Meeting note

Project name	Great Yarmouth Third River Crossing
File reference	TR010043
Status	Final
Author	The Planning Inspectorate
Date	12 June 2018
Meeting with	Norfolk County Council
Venue	The Planning Inspectorate offices, Bristol
Attendees	The Planning Inspectorate Norfolk County Council (NCC)
Meeting objectives	Consultation approach and project update meeting
Circulation	All attendees

TR010043: Great Yarmouth Third River Crossing

Draft Statement of Community Consultation (SoCC) review

Appendix B-2 – Land Referencing Boundary

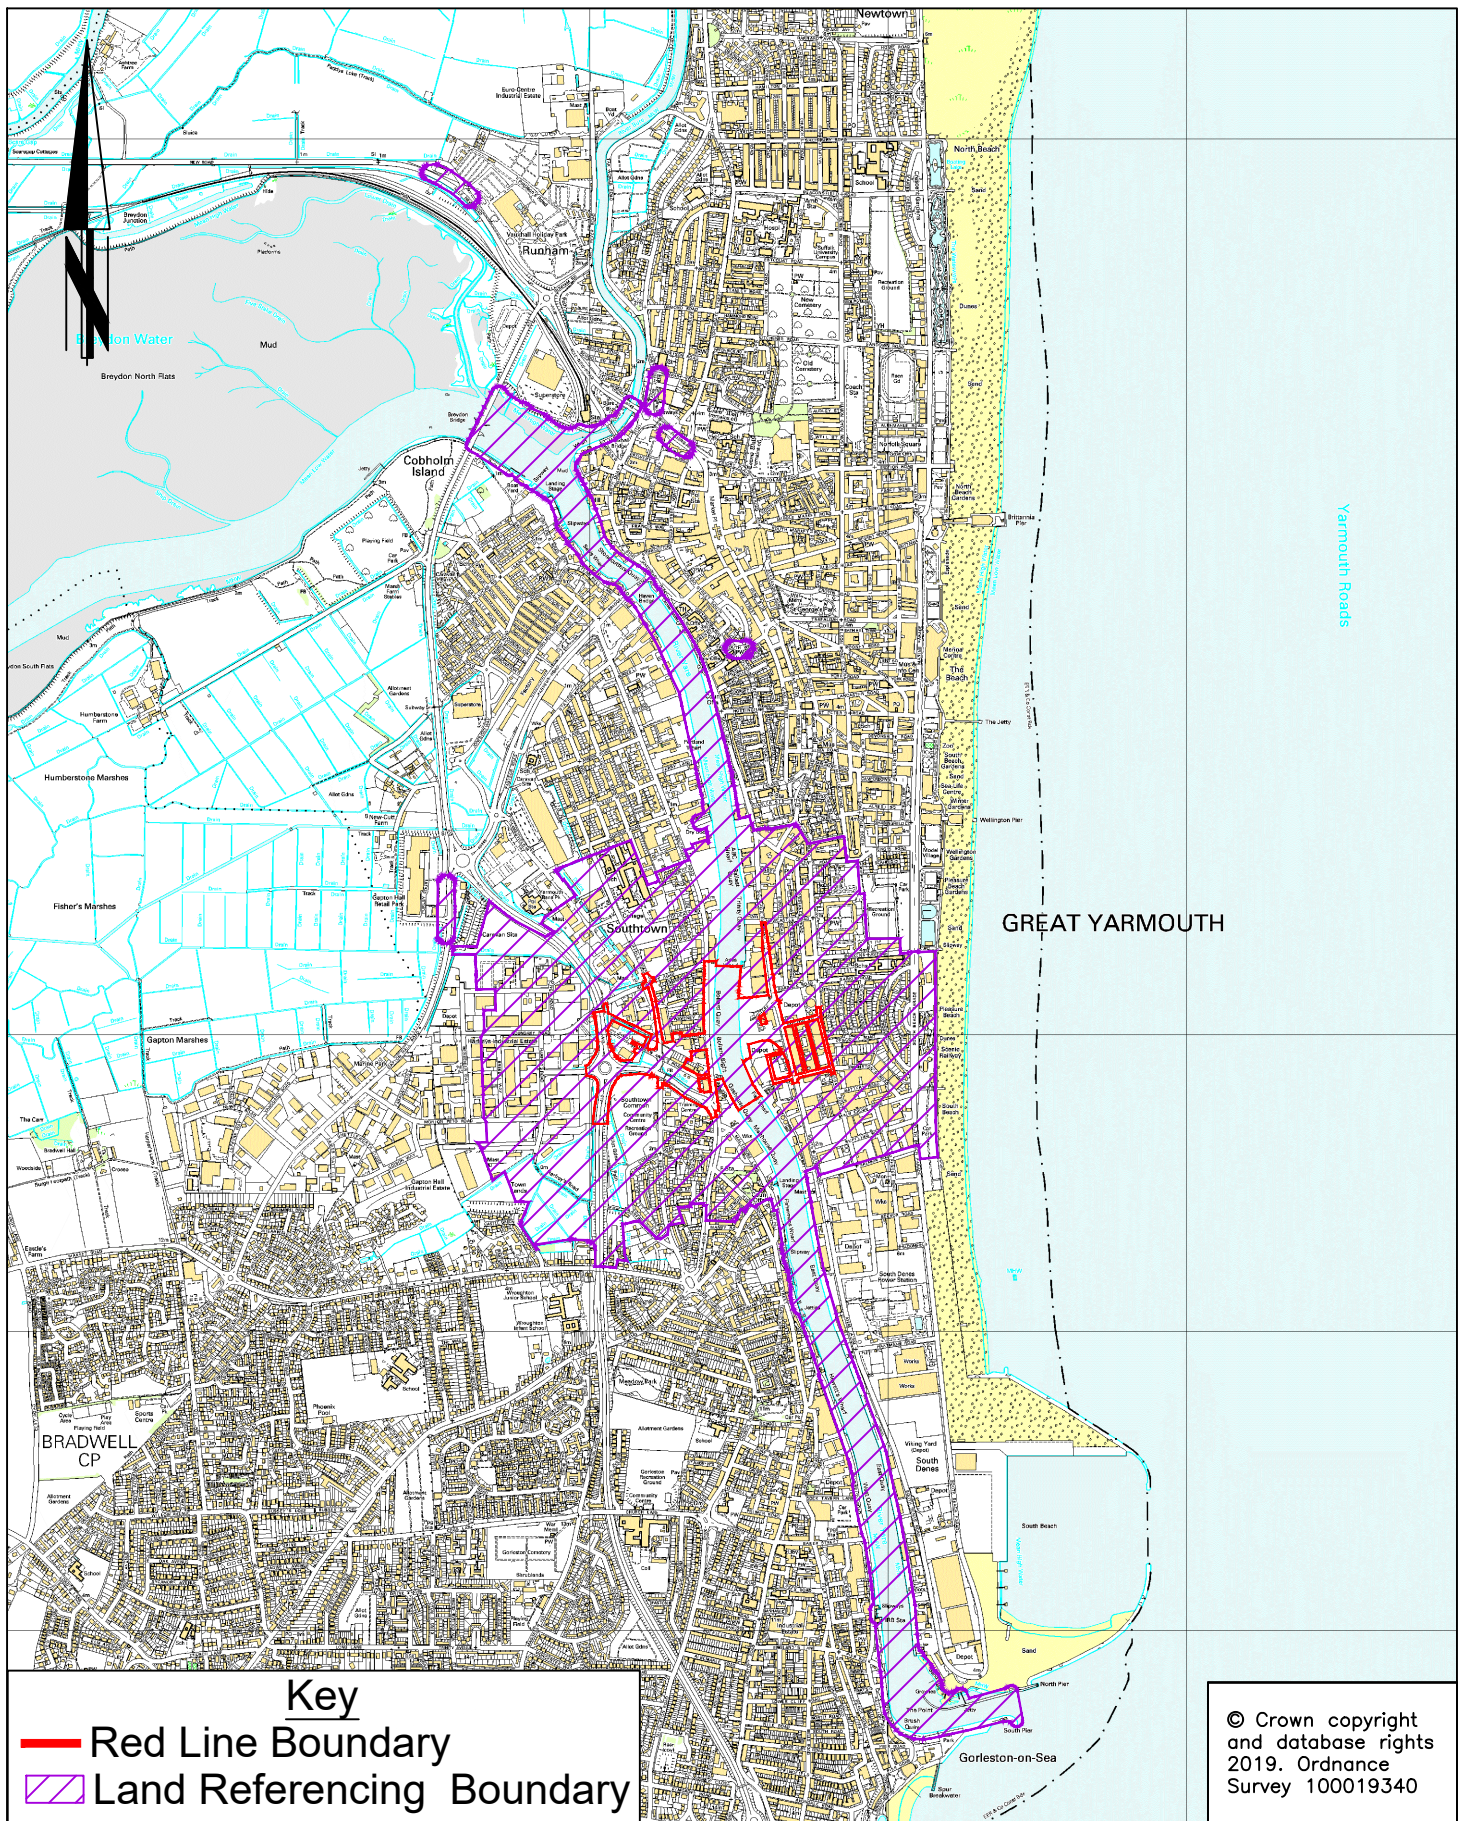
Section 7		
7.2/ 7.3	Prescribed duty	Should the language used make explicit that the applicant 'must have regard to any relevant responses'?
Appendix B		
-	Area boundary	The boundary line is very thick, representing several tens of metres. Does this provide people with sufficient certainty about whether or not they should expect to receive a leaflet?
